Maritime and Coastguard Agency
UK Technical Services Navigation
105 Commercial Road
Southampton
SO15 1EG

Application by North Falls Offshore Wind Limited for an Order Granting Development Consent for the North Falls Offshore Wind Farm.

The Examining Authority's written questions and requests for information (ExQ3)

Examination Timetable – Deadline 7

Figure 4.2 Sunk Routing Measures

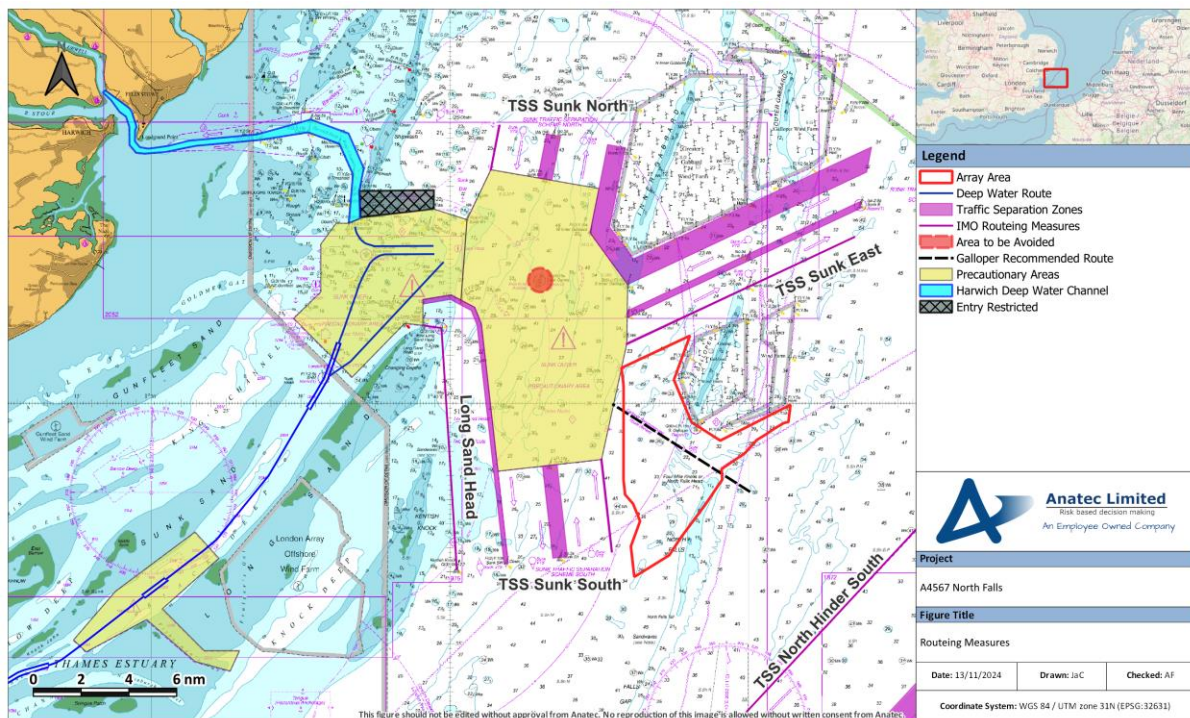
2. Exclusion zone(s) must not be put in place in the Sunk area or channel that would restrict 24/7/365 vessel access requirements or pilot boarding operations etc.

MCA comments: The Applicant will not have the authority to establish mandatory exclusion zones in the Sunk area or channel. Exclusion zones are established under separate legislation e.g. Merchant Shipping Act 1995, therefore it is not necessary to include it within the DCO.

3. Safety zone(s) will not be able to impede vessel traffic movements within the Sunk area or normal operations such as pilot boarding.

MCA comments: Safety zones may be established around wind turbines which will be outside the Sunk Precautionary Area, and therefore they will not impede vessel movements and pilot operations in the Sunk area. Safety zones are established under the Energy Act 2004 and Safety Zone Regulations (SI 2007 1948) and therefore it is not necessary to include it within the DCO.

4. We suggest that no cable joints to be in locations in the Sunk area, due to extra work required in this busy shipping area, leading to increased navigational safety risk.

MCA comments: MCA agrees with this approach and inclusion in the DCO would secure the condition, otherwise the HHA (and other navigation stakeholders) will rely on the MMO including them in the post-consent consultation of the relevant plans to confirm the North Falls project intends to implement the condition. Alternatively, it could be included in the Outline Cable Specification and Installation Plan.

5. In the Sunk area, cable depth needs to consider that the world's largest vessels may anchor and dredge anchors in emergency scenario.

MCA comments: This is addressed through the condition in the Cable Specification and Installation Plan – see below.

Figure 4.3 Charted Galloper Recommended Ferry Route

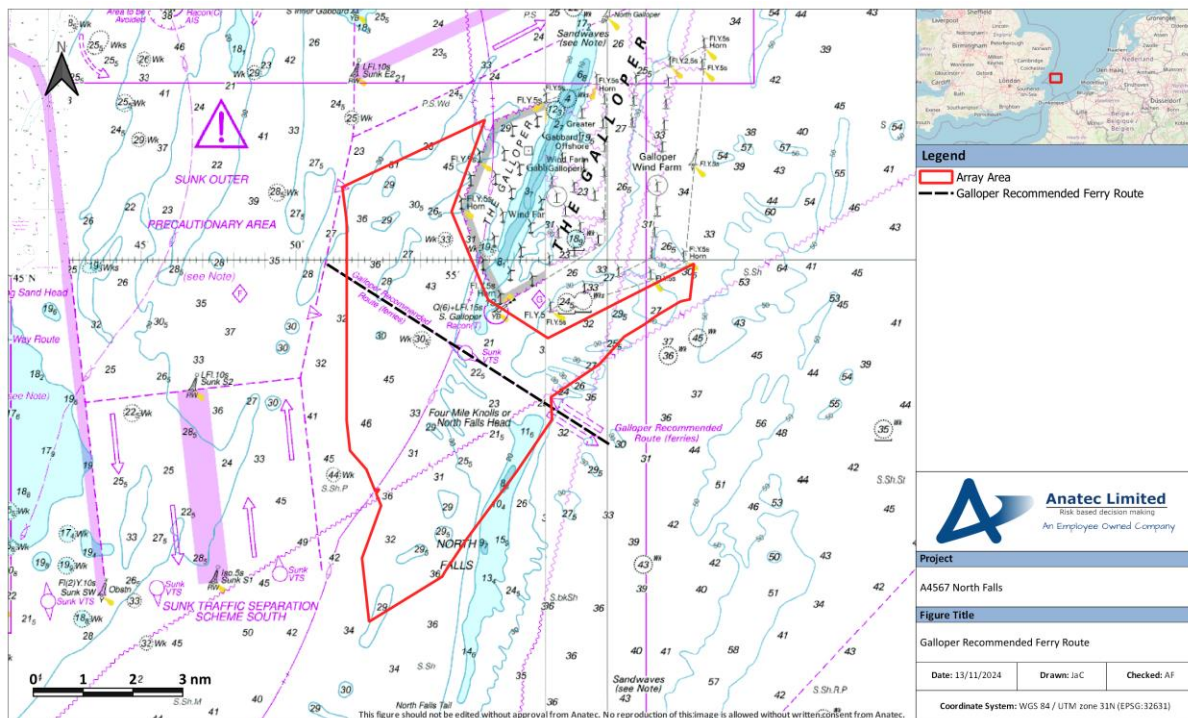
MCA is able to accept sub-paragraph (4); however we do not accept sub-paragraph (5). The IMO is the specialist agency of the United Nations responsible for setting international standards on the safety and security of shipping and the prevention of marine and atmospheric pollution by ships. The IMO provides regulatory frameworks for the shipping industry that are universally adopted and implemented by Member States. IMO-adopted ships’ routeing, as defined by

Recommended Routes are defined in Resolution A.572(14) as “*A route of undefined width, for the convenience of ships in transit, which is often marked by centre line buoys*”. The Galloper Recommended Route was established in 2006 to enable regular ferry traffic sailing to and from the port of Ostend to enter and leave the Sunk Outer Precautionary Area without unnecessarily deviating to use the Traffic Separation Scheme. Other vessel types can and do use the route. Resolution A.572(14) goes on to say:

3.10 Governments are recommended to ensure, as far as practicable, that oil rigs, platforms and other similar structures are not established within routeing systems adopted by IMO or near their terminations.

Proposals that require static sea surface infrastructure or that significantly reduce under-keel clearance should not be authorised in International Maritime Organization designated routes.

It is also MCA's position that as an IMO-adopted routeing measure the Galloper Recommended Route is a 'strategic route essential to regional, national and international trade' under paragraph 2.8.318 of EN-3 National Policy Statement for Renewable Energy Infrastructure.

As explained during Issue Specific Hearing 2 and in our Deadline 4 response, MCA will not propose the removal of the Recommended Route to IMO until the project receives Ministerial consent. The proposal will be a joint submission from the UK and Belgian Governments and therefore it is not considered to be a minor amendment as suggested by the Applicant in their proposed condition wording. If agreement to remove the Recommended Route is not received from the IMO because of, for example, delays or objections from Member States, the IMO-adopted routeing measure will continue to exist and the UK's obligations in regard to its operation (ref. East Marine Plans PS1 policy) will also continue to exist, regardless of whether the DCO condition has a timebound clause.

Should the Secretary of State grant development consent without an appropriately worded DCO condition, the construction of the wind farm over the Galloper Recommended Route would contradict IMO recommendations and contravene the Government's East Marine Plan policy. Should the Secretary of State grant development consent with a DCO condition using the Applicant's suggested wording for sub-paragraph (5), it potentially consents the Applicant to construct the wind farm after 30 November 2028 without IMO approval to remove the Recommended Route, contrary to IMO recommendations, the East Marine Plan ports and shipping policy, and MCA advice. Sub-paragraph (5) is therefore unacceptable to MCA and we request it is removed from the condition.

Deep Water Route Cable Installation Areas (Future Dredging Depths) Plan

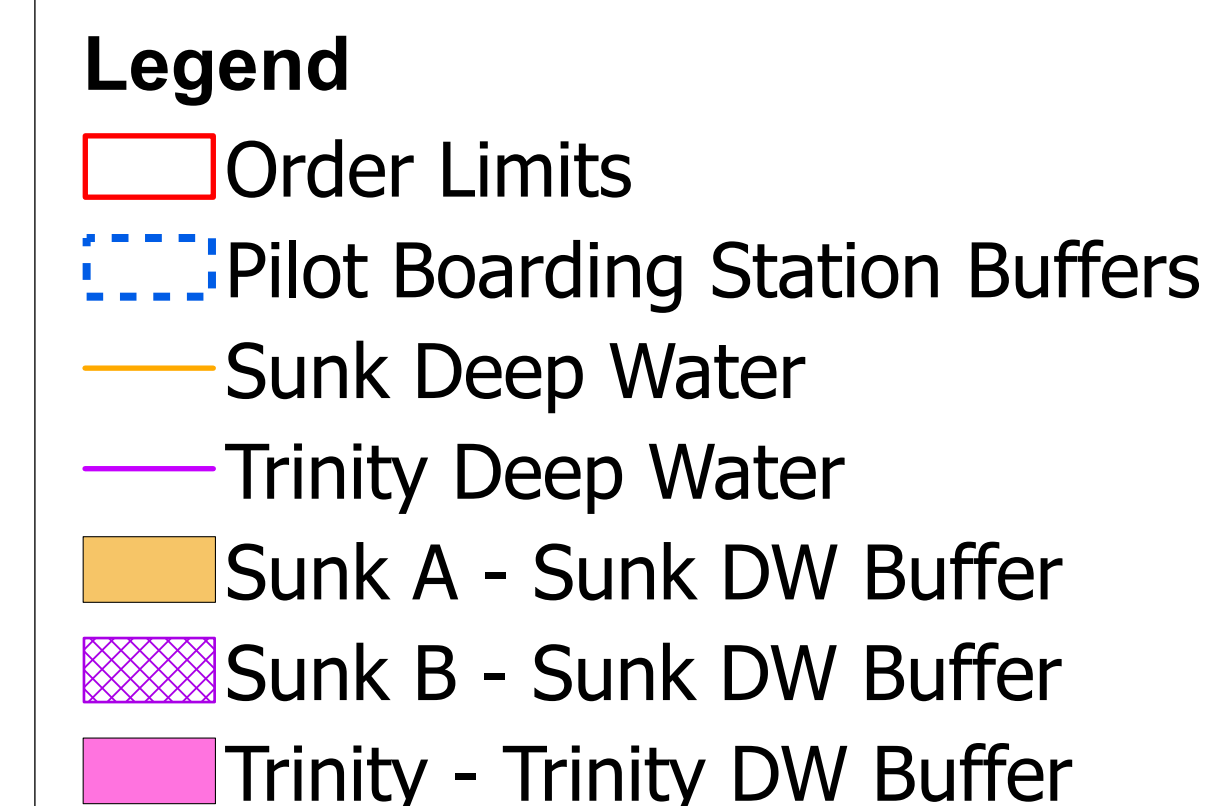
6. The cable depth must take into account the draught of current and future vessels and future dredging. The DCO should provide for a maximum draught of 20m plus 10% UKC, as such minimum depth required 22m below chart datum.

<p>MCA comments: Whilst it could be beneficial to have a specific reference to 22m below CD, it is noted that Schedule 8, Part 2, 22(h) requires the cable specification and installation plan to be in accordance with the outline cable specification and installation plan where it confirms:</p> <p>“Cables will be installed and maintained so as not to impede dredging to a depth of at least 22m below CD within the DWR areas Sunk A and Trinity”.</p> <p><i>7. Suggest that no project vessels with Restricted Ability to Manoeuvre (RAM) (cable laying, UXO clearance, survey etc) are to operate in the wider Sunk area when visibility below nautical 2 miles.</i></p> <p>MCA comments: MCA agrees with this procedure. This could be secured within the Outline Navigation and Installation Plan.</p>
--	--	---
